**From:** Jeff Tarling  
**To:** Jean Fraser  
**Date:** 1/23/2014 8:41 AM  
**Subject:** Re: 133 York

**10 greenscreen® VINE PLANTING DETAIL**  
NOT TO SCALE

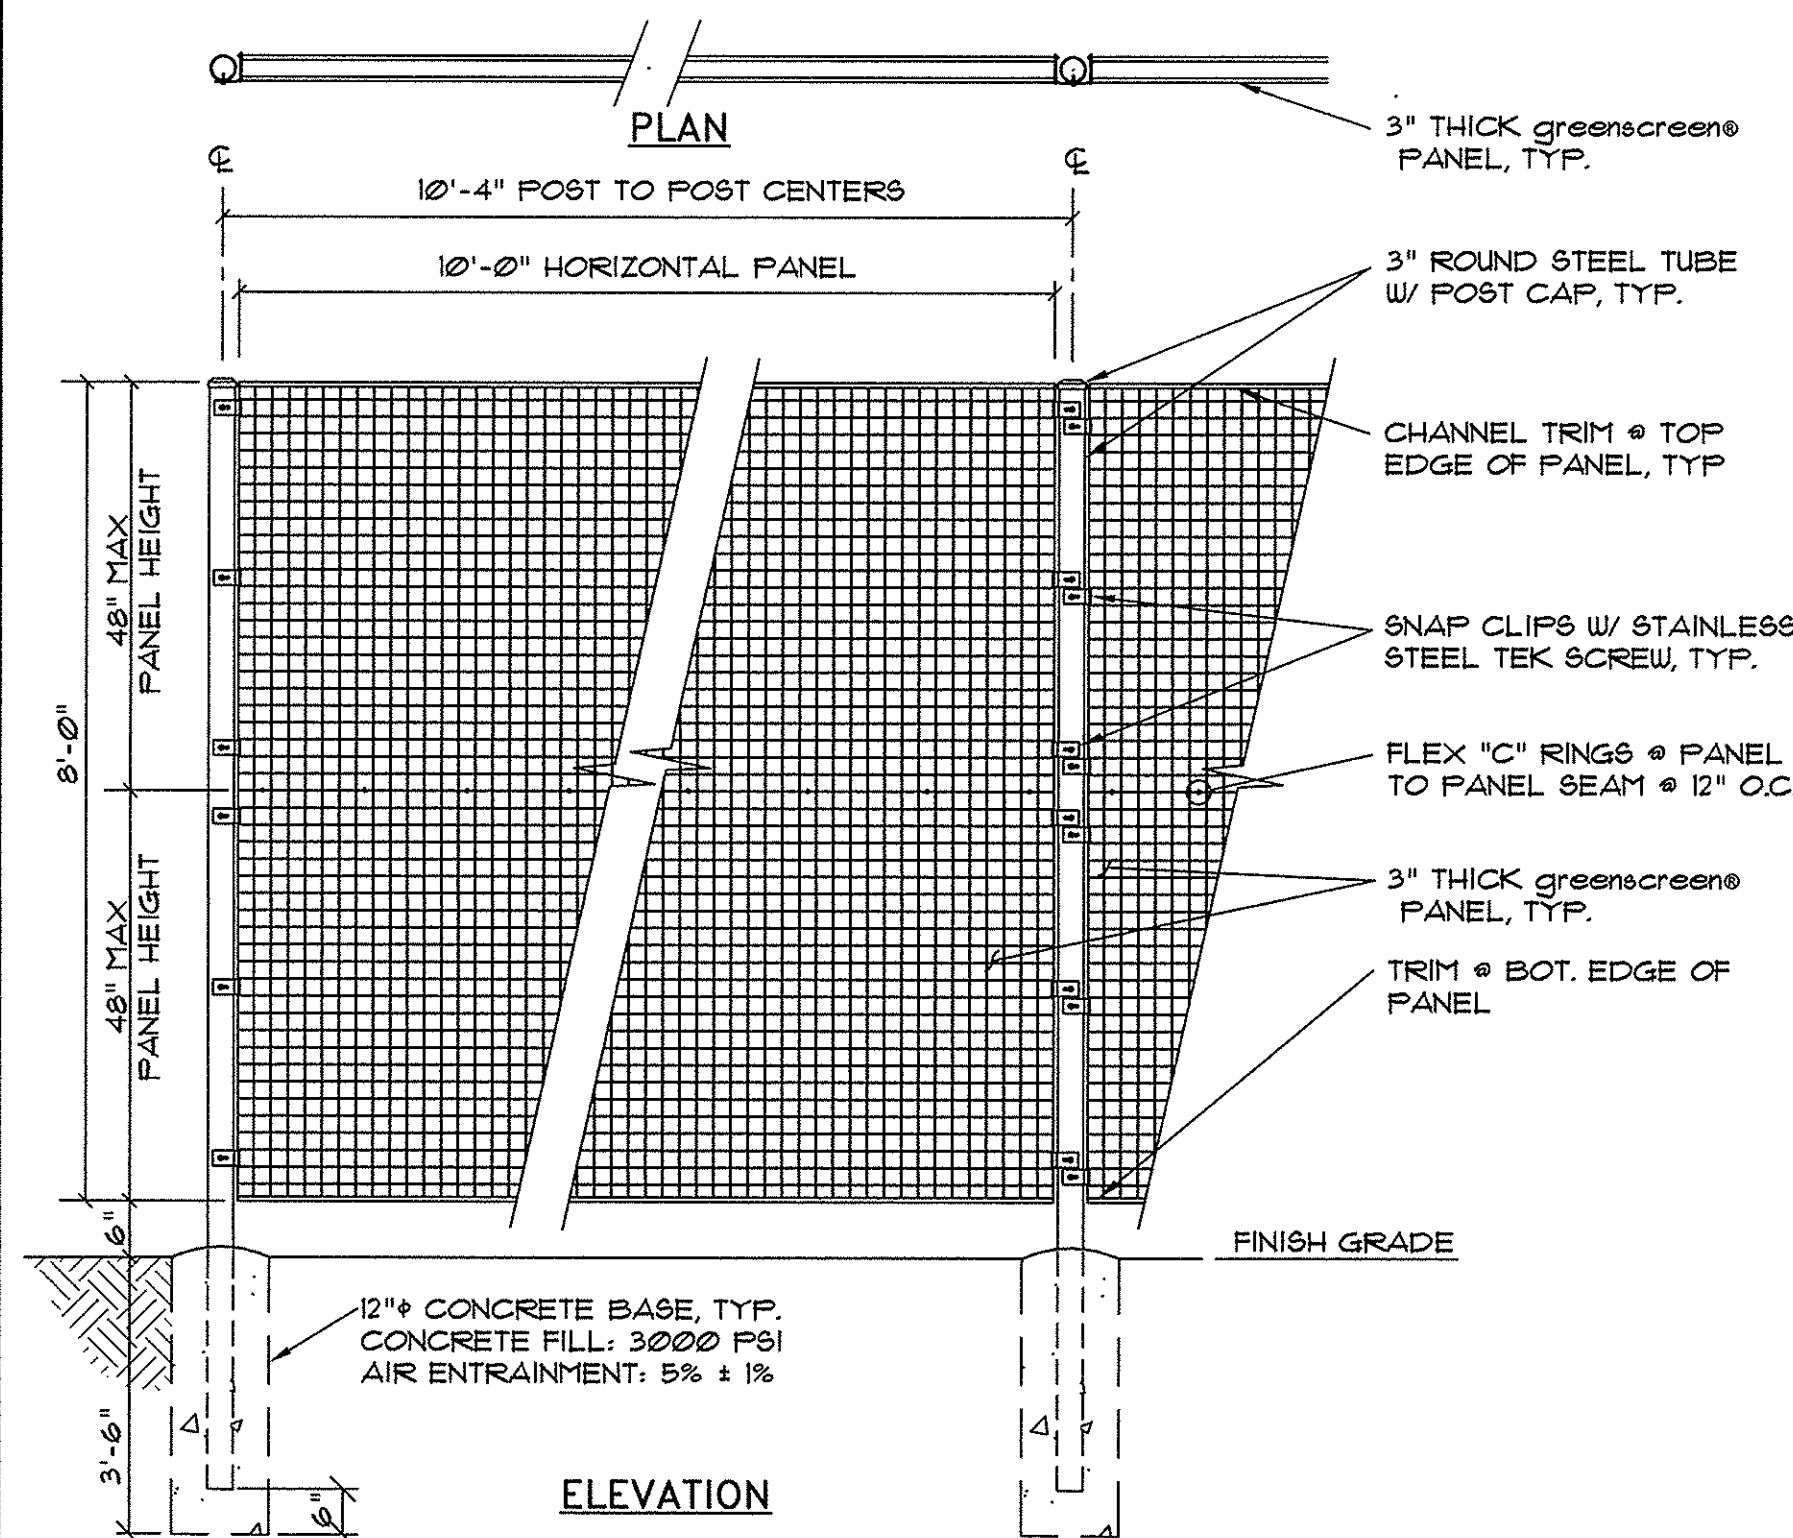
The hydrangea size should be #5 gallon pot size minimum, proposed #1 gal size is too small to provide any screening for several years, this buffer is an important feature of the landscape plan. Ideally, every fourth plant could be a #7 size pot to add some height to the planting from the start. Climbing Hydrangea are slow growing.
